**MODIFICATION OF MAJOR PROJECT 09_0122 FOR EXCAVATION AND
CONSTRUCTION OF STORMWATER DRAIN AT SYDNEY OPERA HOUSE**

Reference is made to the abovementioned project, for the proposed modification to provide a new stormwater outlet in the Eastern Seawall to replace an existing outlet, which is being removed.

SOH - EASTERN SEA WALL Proposed Amendments to Stormwater Outlets

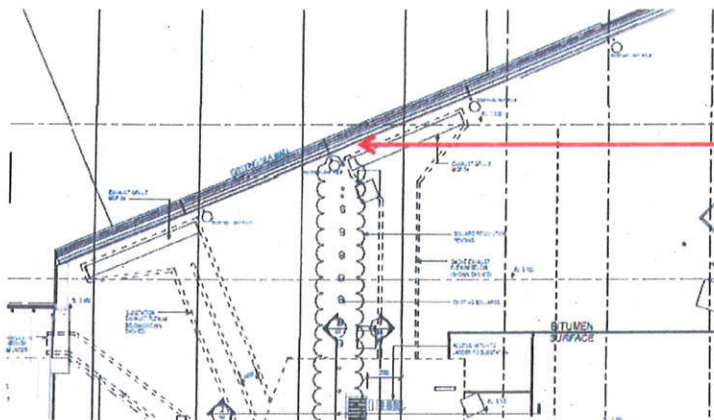
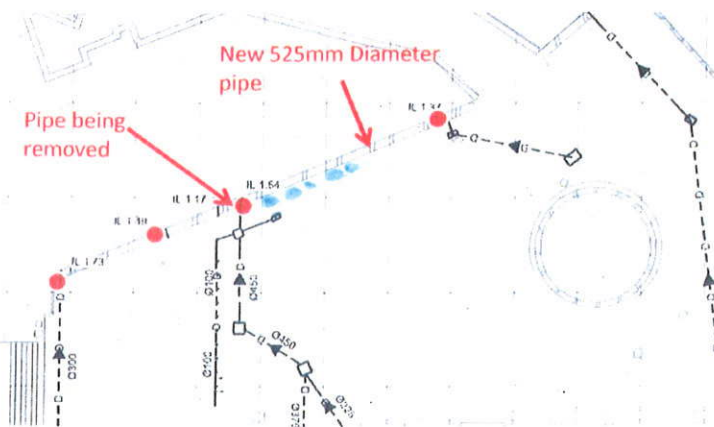
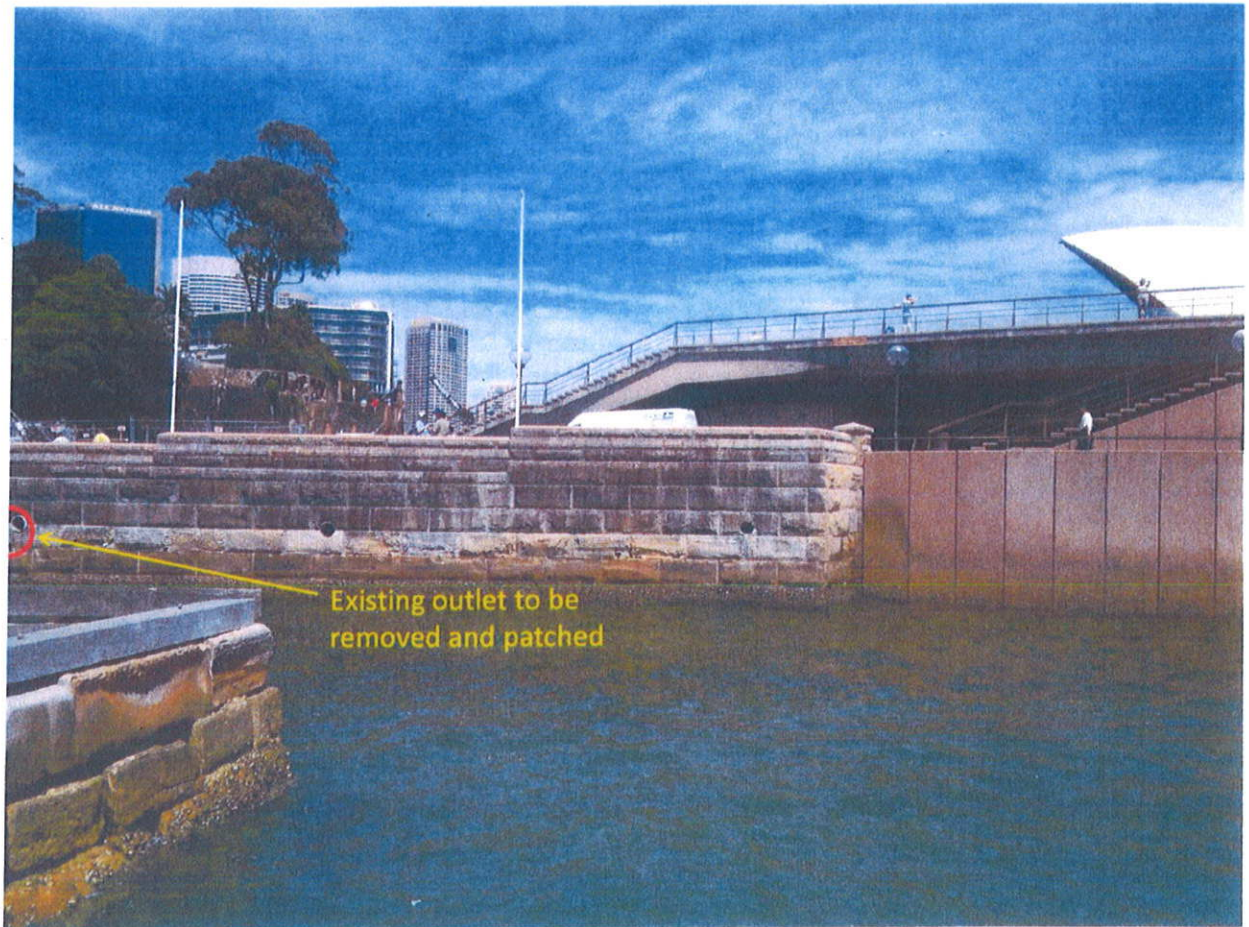
The City considers that the proposed outlet is too large and will be visually intrusive at lower tides and should be decreased in size. It is also noted that no heritage impact statement has been provided that discusses any different options that may have been explored.

The City therefore recommends that the pipe be bifurcated and exit in two separate locations using pipe sizes similar to the existing.
